**From:** Thomas Whitfield <thomas@georgiangroup.org.uk>  
**Sent:** 01 June 2023 13:22  
**To:** Planning  
**Subject:** Case 3/2023/0132 - Former Punch Bowl Inn, Longridge Road, Hurst Green

Thank you for notifying The Georgian Group of application 3/2023/0132 to undertake a scheme of works at Grade II listed 'Former Punch Bowl Inn', Longridge Road, Hurst Green. The Group strongly objects to the application on the following grounds.

The present application is to erect a building on the site of the former Punch Bowl Inn in a revised location and with significant internal and external deviations from the pre-demolition building plans to form 6no. holiday lets and 1no. managerial apartment.

REAR ELEVATION  
PROPOSED ELEVATIONS

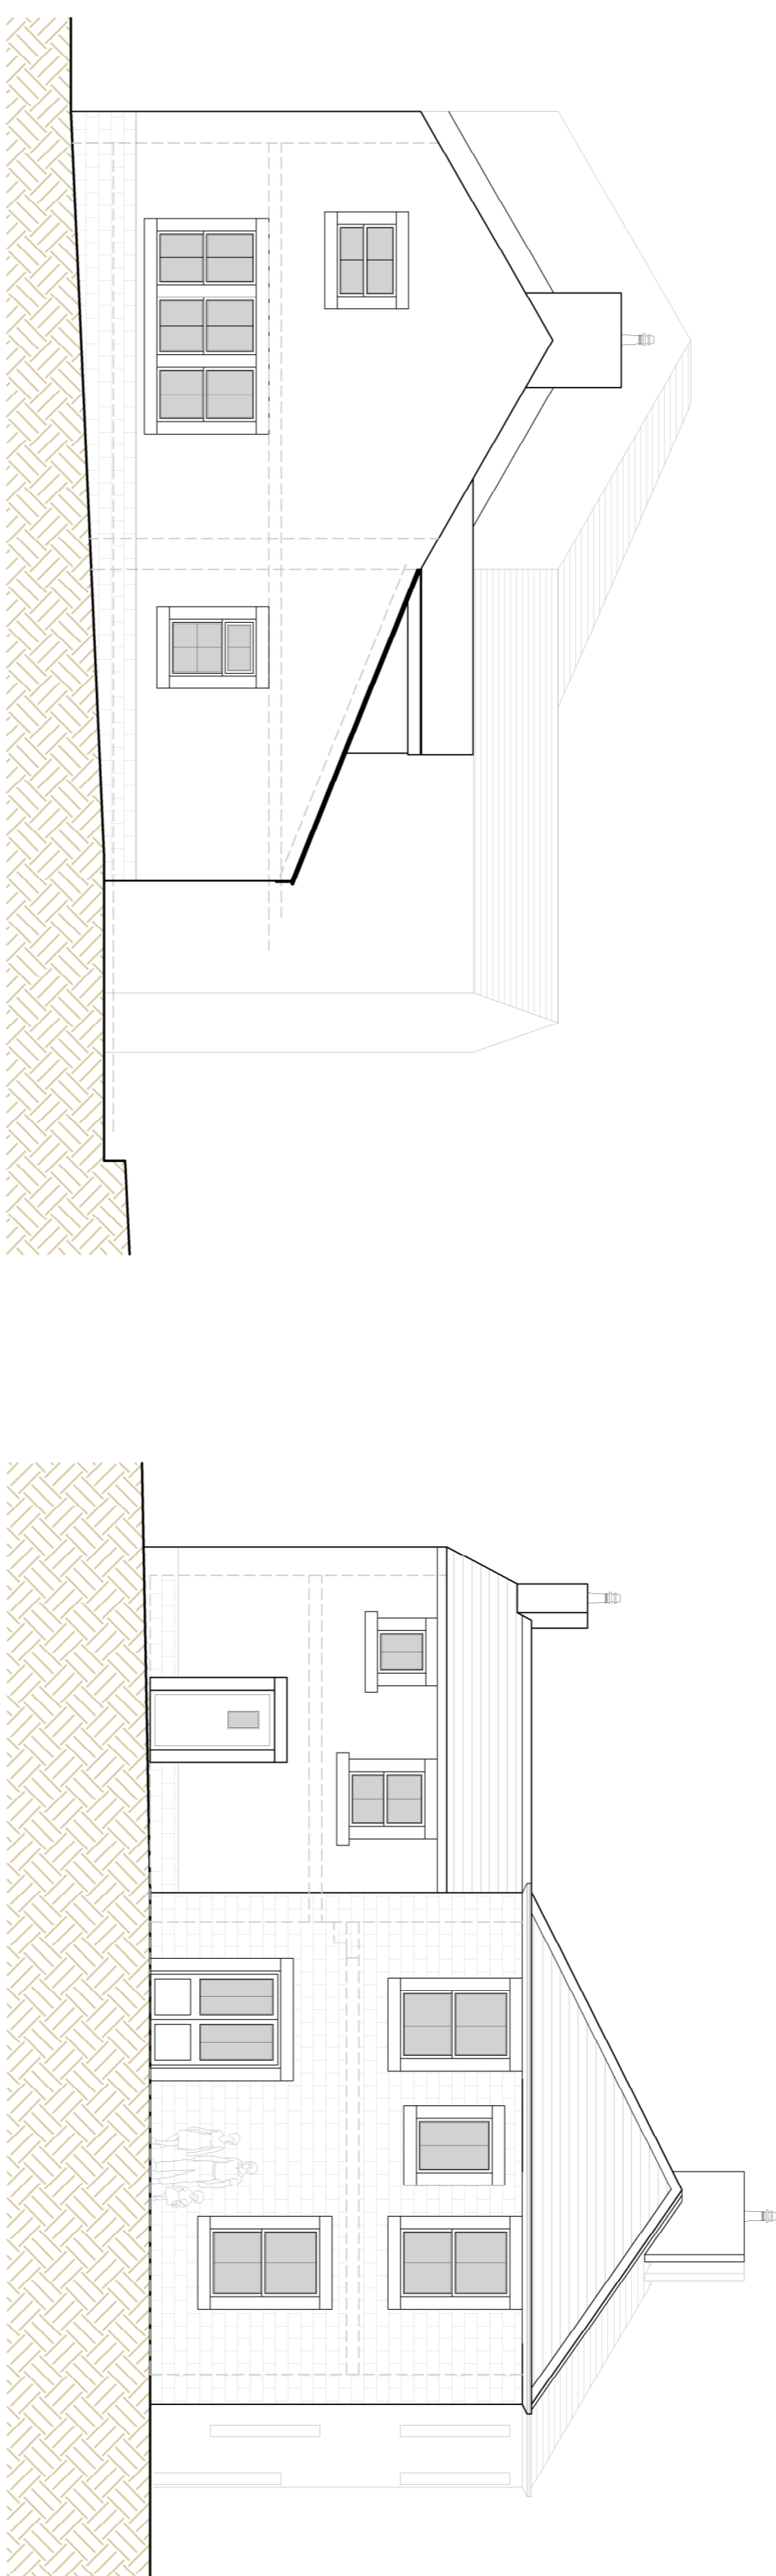
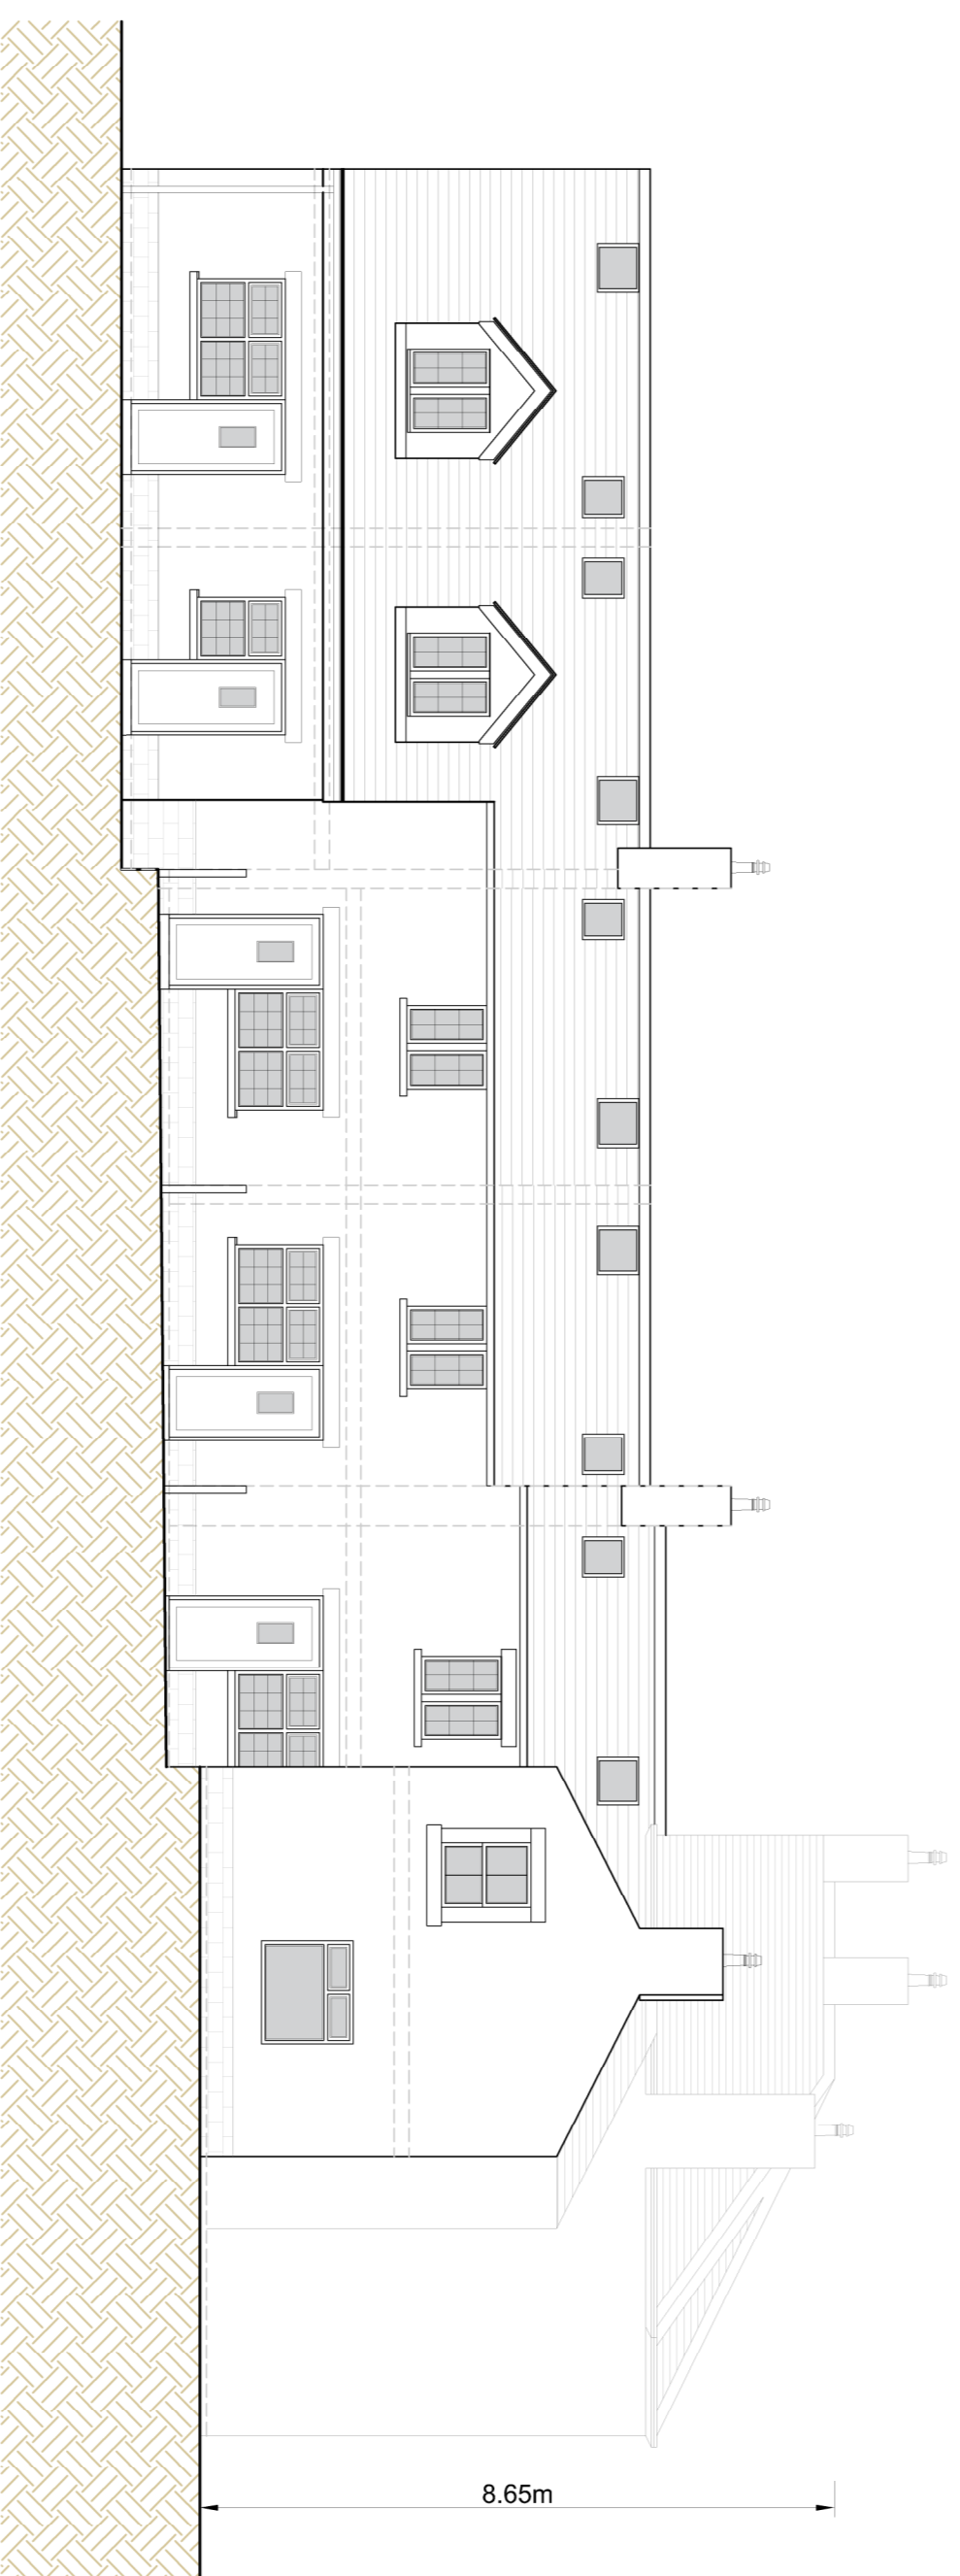
The Group further advises that the present proposal also fails to fulfil the terms of the enforcement notice issued by RVBC by proposing to relocate and rotate the building further away from the road.

The Group advises that the form of the building with a distinctive curvature to the principal elevation is the result of the building's historic development in relationship to the road, we advise therefore that location and form of the building are intrinsically linked and that the building's relationship with the road should be considered as contributing to its setting and significance. The proposed relocation of the building moving it away from the road and rotating it would decontextualise this relationship causing some harm to the building's historical and evidential value.

The Group advises that the proposed scheme of works would cumulatively cause substantial harm to the special architectural and historical significance of the former Punch Bowl Inn as a Grade II listed heritage asset. We further advise that the proposals fail to fulfil the requirements of RVBC's enforcement notice due to the variances with the pre-demolition building.

The Group must therefore recommend that the applicant withdraws this application and revises it to first and foremost reinstate the building in fulfilment of the RVBC's enforcement notice. We advise that once this reinstatement has been completed may then apply for consent to convert the building to the proposed holidays let use. If the applicant is unwilling to do so, listed building consent should be refused.

PROPOSED GROUND FLOOR PLAN

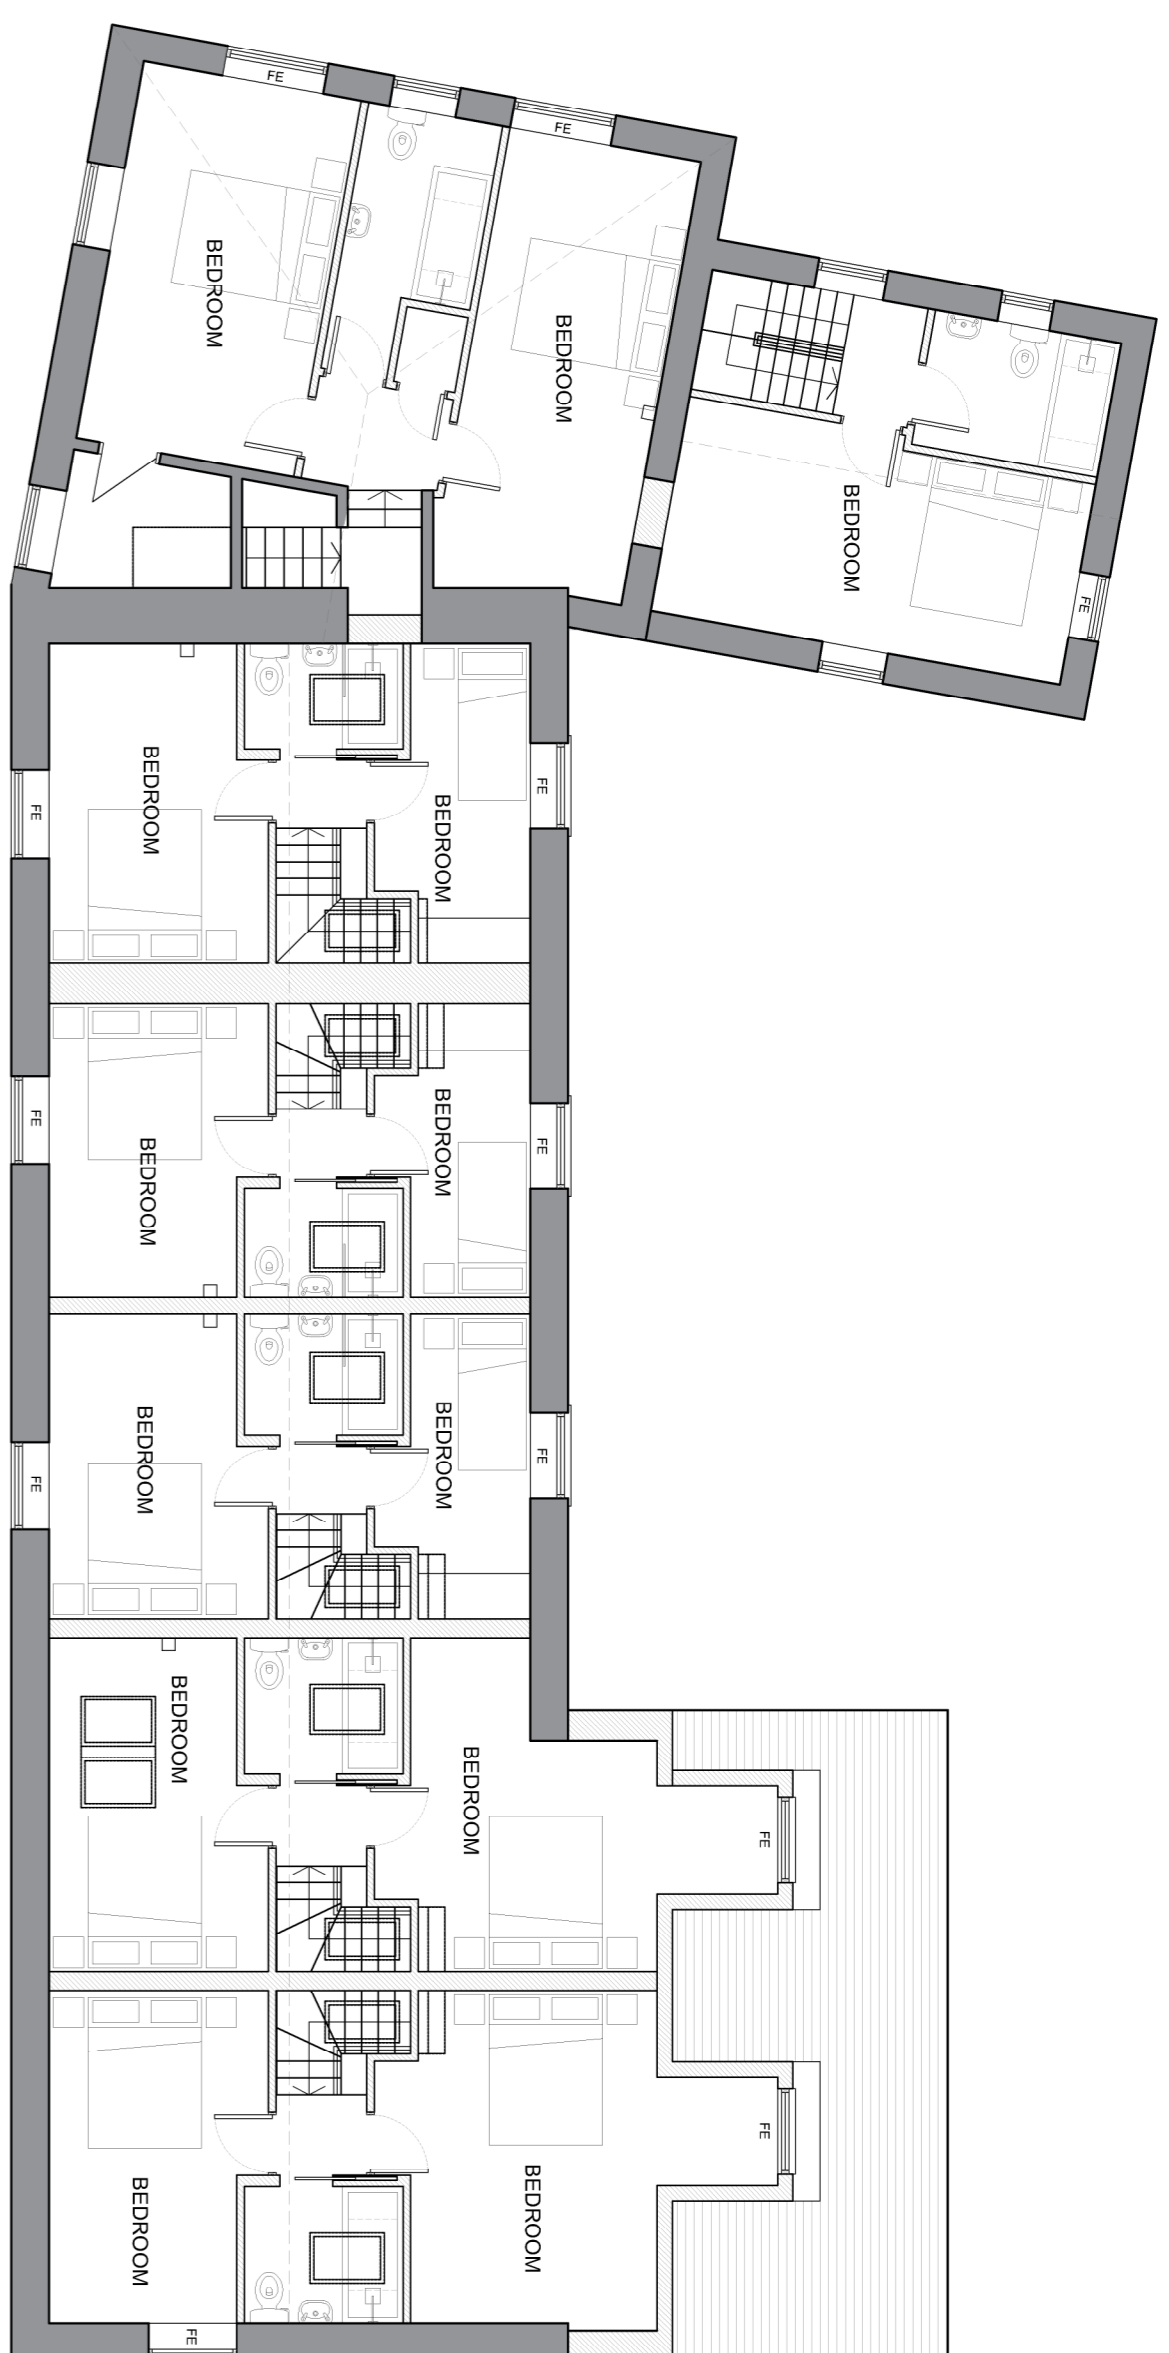
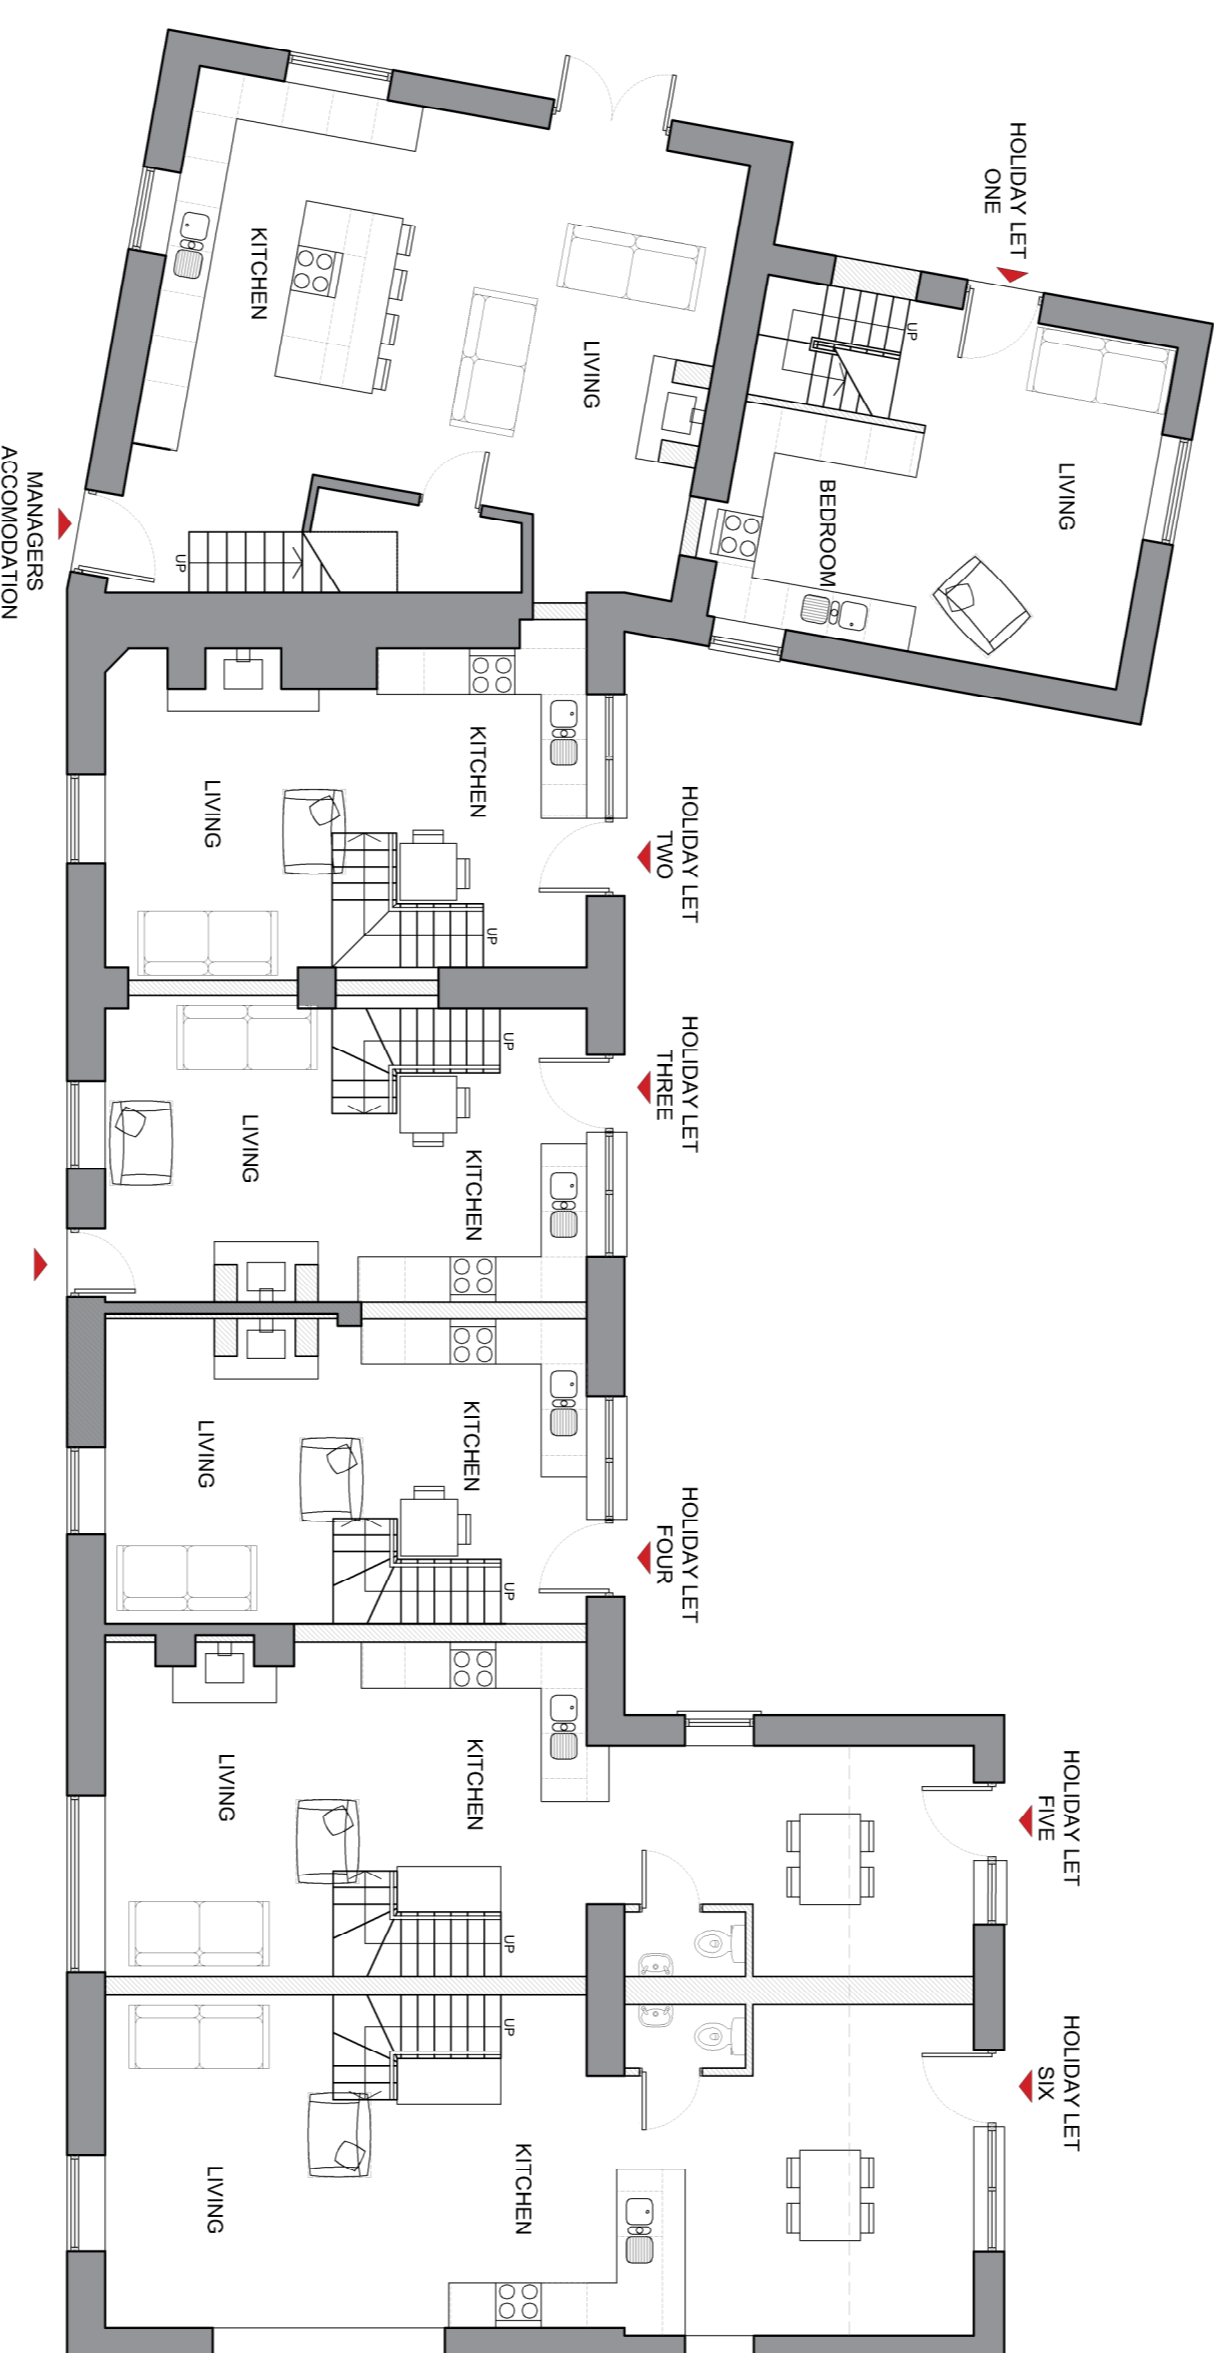
The Group advises that the supporting documentation for the proposed works fails to provide adequate information regarding the proposed materials for use. We advise that the rebuilding should reuse as much salvageable original fabric as possible. We advise that historically and architecturally significant elements of the building such as the date stone should be reinstated.

The Group advises that the proposed conversion to form 6no. holiday lets and 1no. managerial apartment should only be appropriately considered from the position of the listed building pre-demolition.

We advise therefore that the proposed conversion of the building to form holiday lets should be submitted as a separate application to alter the building after its restoration to its pre-demolition form. We recommend therefore that this element of the proposal is omitted from the present application and that this application focusses on reinstating the building to its pre-demolition form and appearance.
